REFUSAL OF PLANNING PERMISSION

APPLICATION NO. 2013/1255

**Proposal Conversion of a three storey dwelling into two apartments.
At 69 Park Road, Worsbrough, Barnsley, S70 5DD**

FLOOR PLANS AS PROPOSED

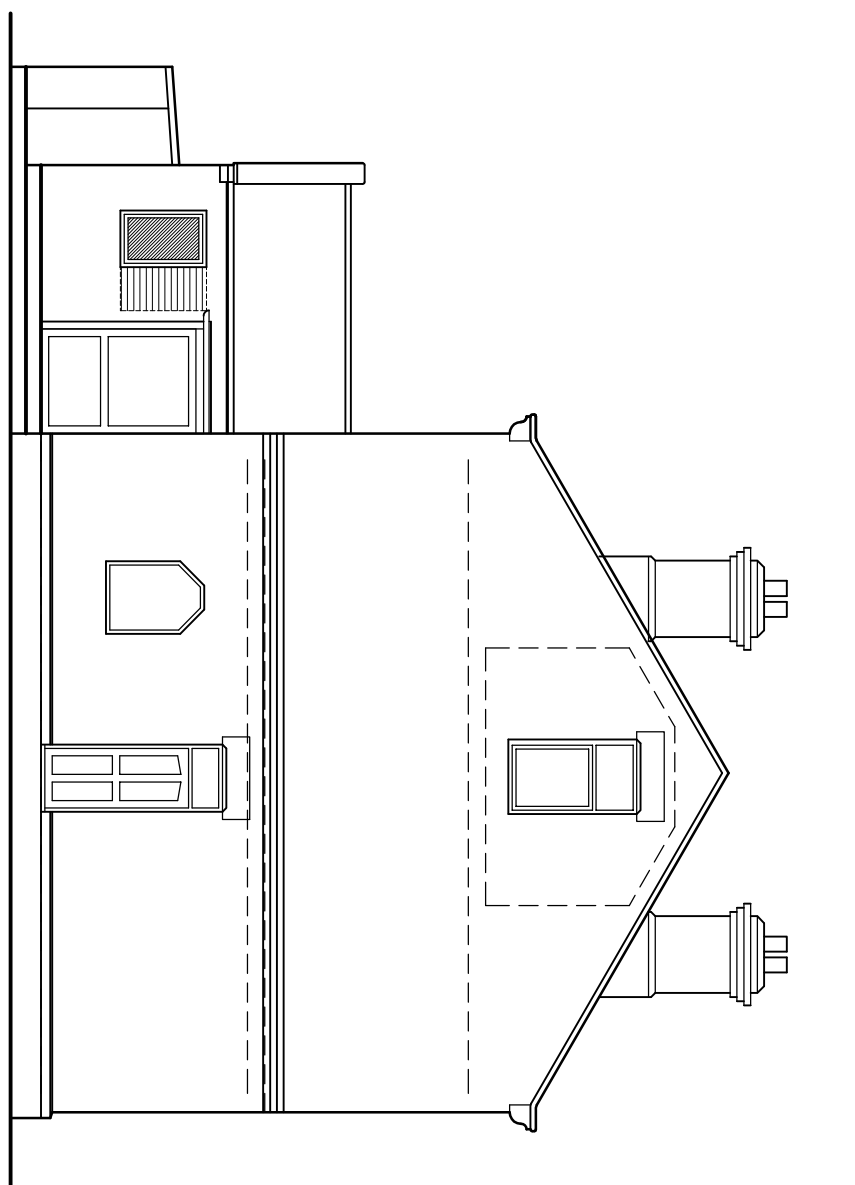
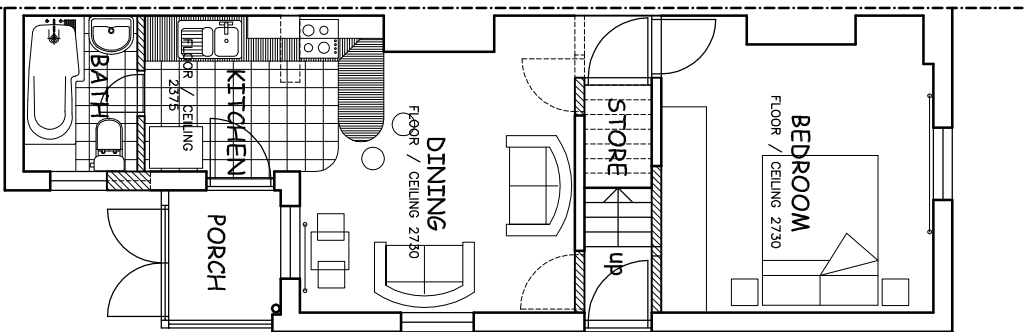
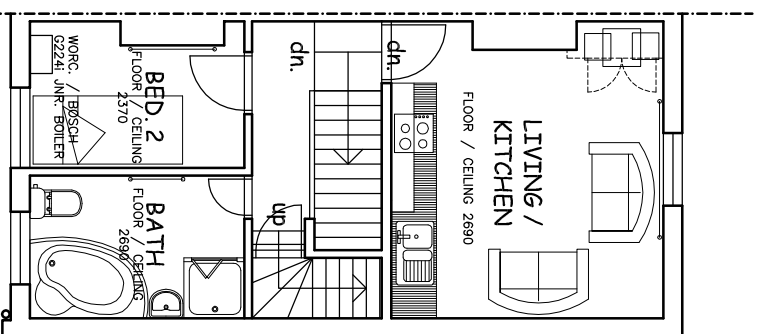
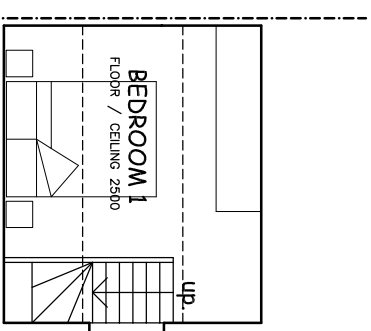
- 1 The occupants of the proposed apartments would not be provided with sufficient levels of amenity by virtue of the size and layout of the apartments. As such, the proposed development is contrary to the Designing New Housing Development SPD, Core Strategy Policy CSP29, emerging Development Sites and Places Policy GD1 and the fourth core principle in the National Planning Policy Framework and planning policy statements relating to requiring good design, which require high quality design and good standards of amenity for the future occupants of buildings.
